# Planning Application 20/01073/F use of site for Recreational Caravan Park To include a new amenity building containing reception, toilets showers and washing <u>facilities.</u>

REV	DATE	DESCRIPTION	DRAWING TITLE	PROJECT NO.	DRAWING NO.	REV
CLIENT	MRS K. MACDONALD		PROPOSED CAMP SITE	P20-077	02	-
PROJECT	ADDERBURY HILL BARN MILTON ROAD ADDERBURY, OXON OX17 3HN		AMENITY BUILDING ELEVATIONS			
		SIZE A3	ISSUE DATE 14-Apr-20	SCALE 1:100	STATUS	Planning

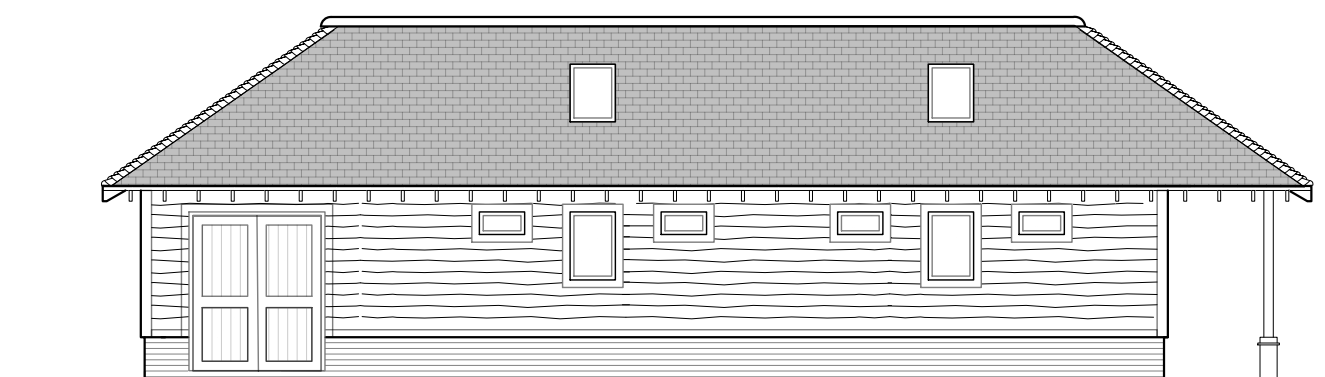
The only suggested permanent feature of this development is the timber-clad single storey reception and ablutions block which appears too small for 73 caravans. The proposal includes hard standing internal roads and proposed perimeter tree-planting which will (with 73 caravans) damage the character of the open countryside on the outskirts of Adderbury. There few, if any, open spaces within the site for recreation and a there is a minimum of on-site facilities. The plan as drawn in the application shows 73 pitches with little space for other recreational activities which further confirms that it is designed for overnight stops or submitted for the sole purpose of gaining a further change of use which will then be sold on for residential (static trailers) and traveller use.
